**WEST SUSSEX COUNTY COUNCIL
PLANNING SERVICES CONSULTATION**

SUBJECT: AL/5/18/RES - Approval of reserved matters following outline consent AL/75/14/OUT for 2 No. dwellings.

Woodgate Farm, Westergate Street, Westergate, PO20 3SS

title: Site Block Plan with Visibility Splay

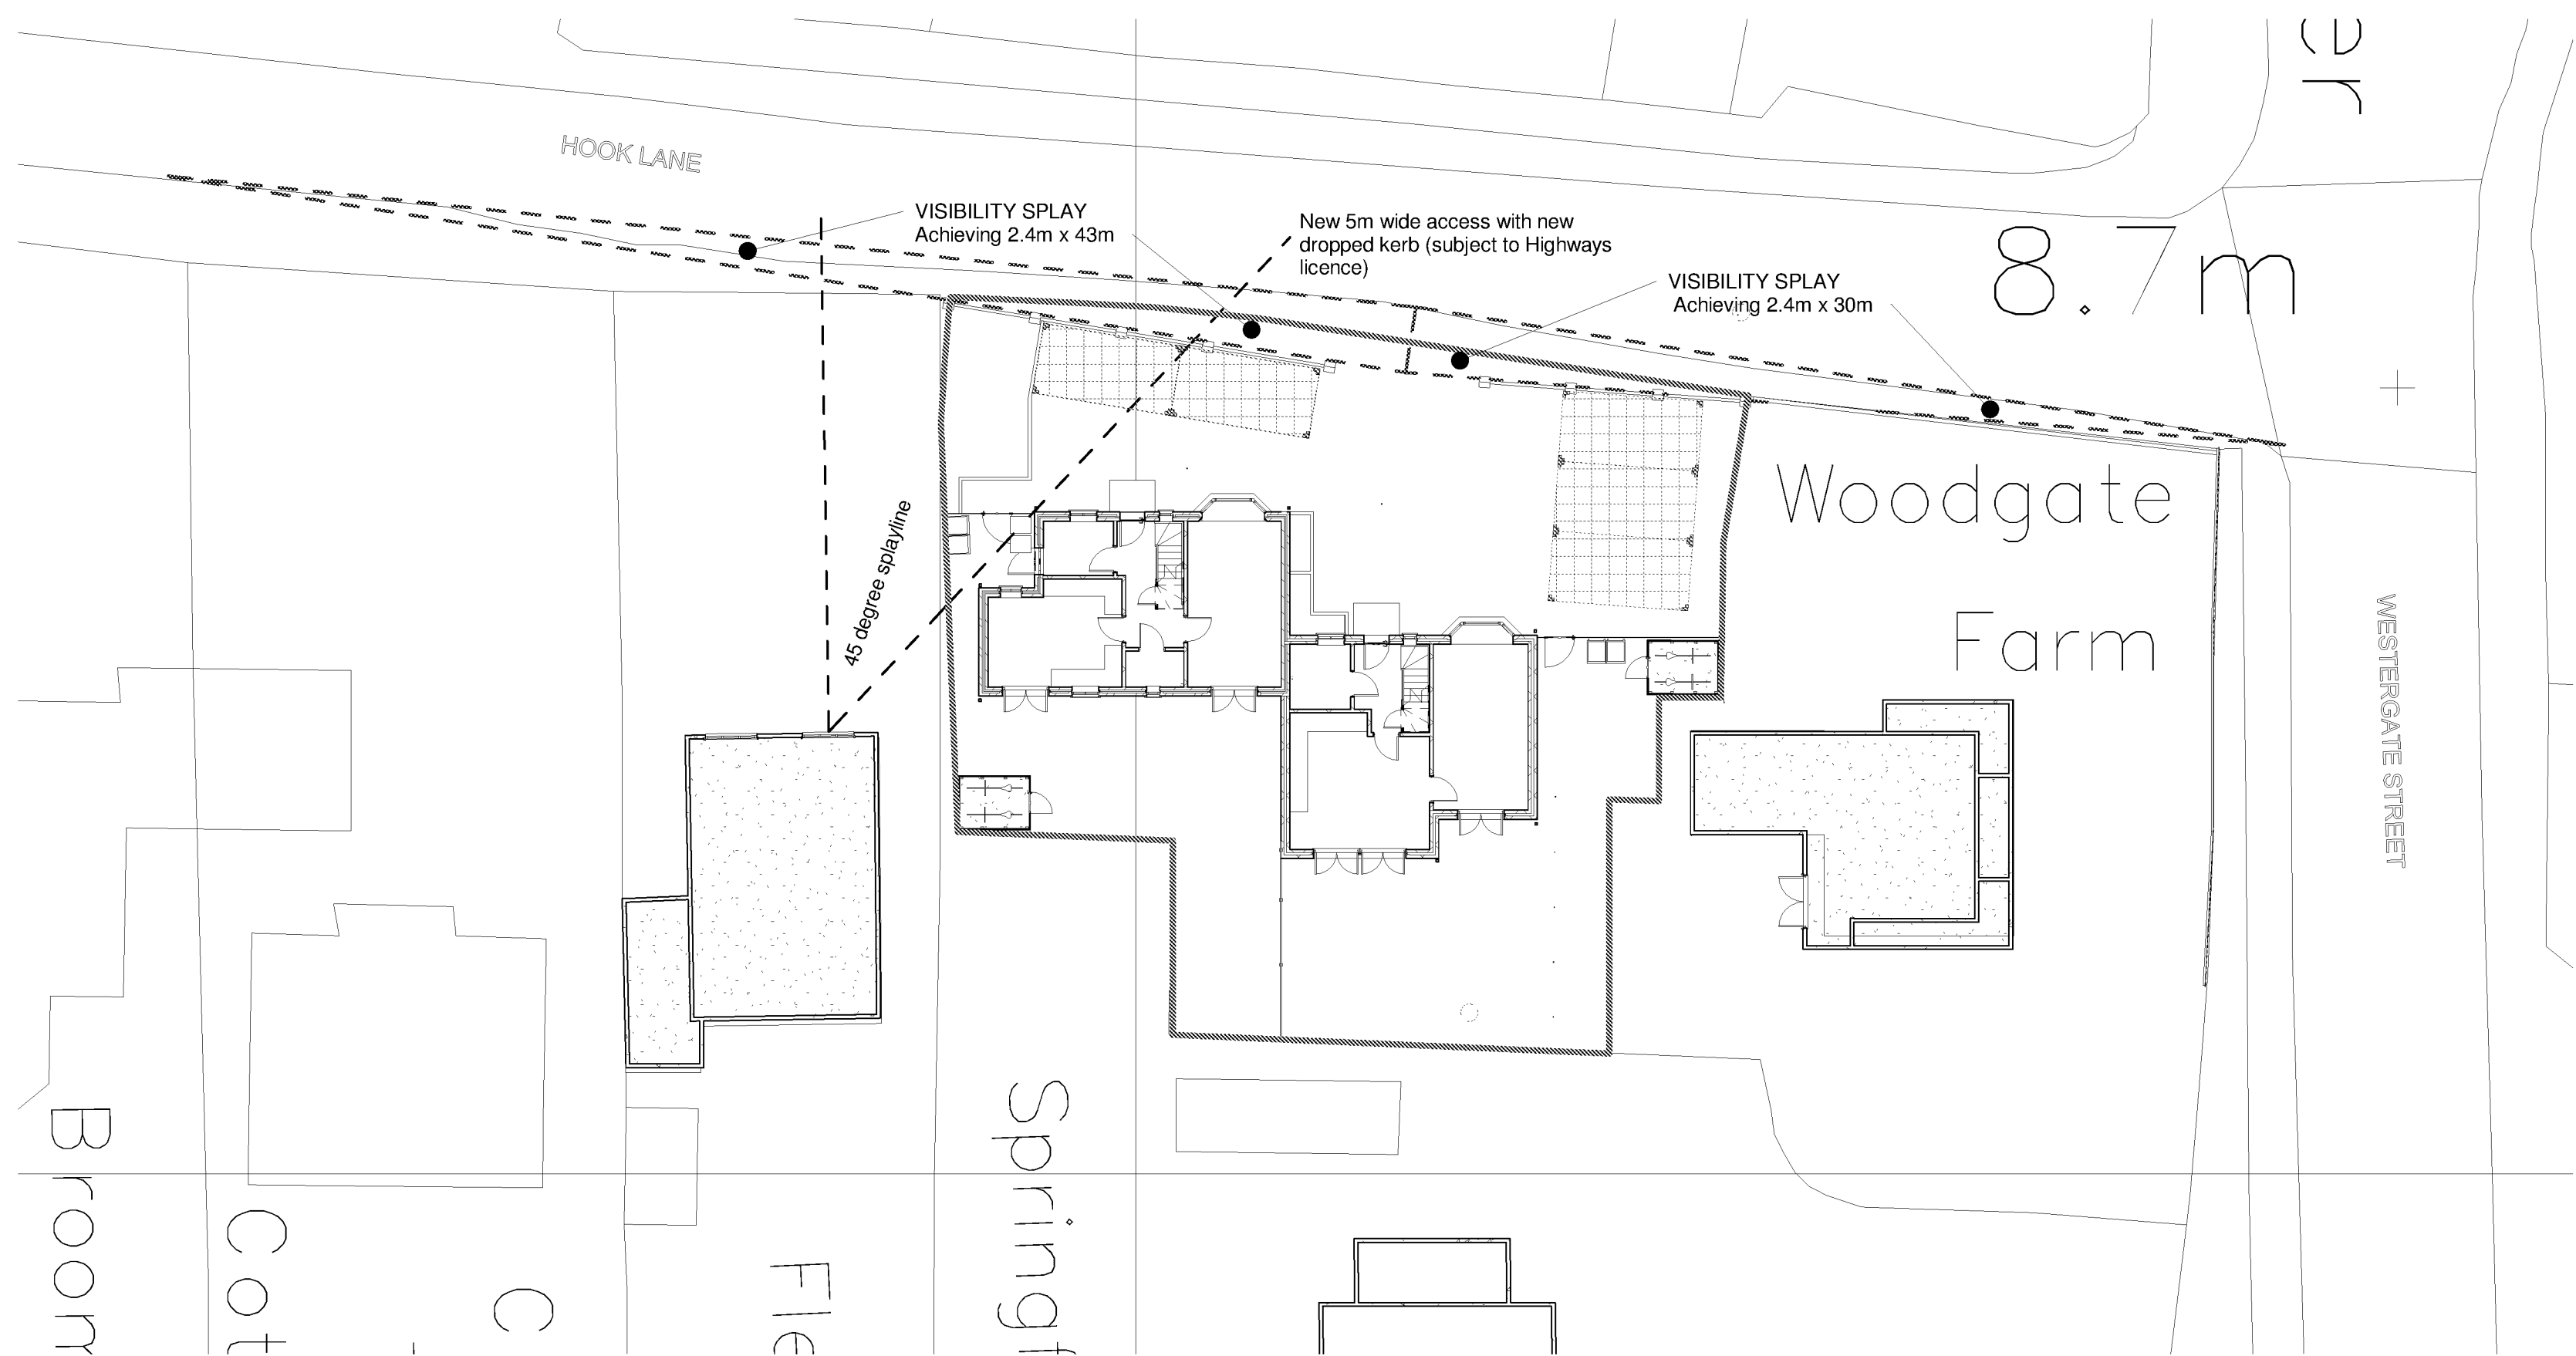
The applicant has demonstrated that 5 car parking spaces will be provided, two of which will be provided in tandem.

Each hardstanding parking space should measure 2.4 x 4.8 metres. I note this does not seem to be the case with all spaces; though could be achieved with some minor modifications to the hard and soft landscaping.

On the basis that each dwellings is allocated two parking spaces the total provision of 5 spaces would be considered adequate to meet the needs of the development. It would be beneficial if one of the spaces remain unallocated as a 'visitor' car parking space.

In conclusion the matters relating to Appearance, Layout, Landscaping and Scale would be considered acceptable to the Local Highways Authority, subject to a slight modification to ensure all parking spaces measure 2.4 x 4.8 metres. If the Local Planning Authority deem appropriate such modifications could be secured via planning condition, though some modifications to the soft landscaping would be anticipated.

No part of the development shall be first occupied until the vehicle parking and turning spaces have been constructed in accordance with plans and details submitted to and approved by the Local Planning Authority. These spaces shall thereafter be retained for their designated use.
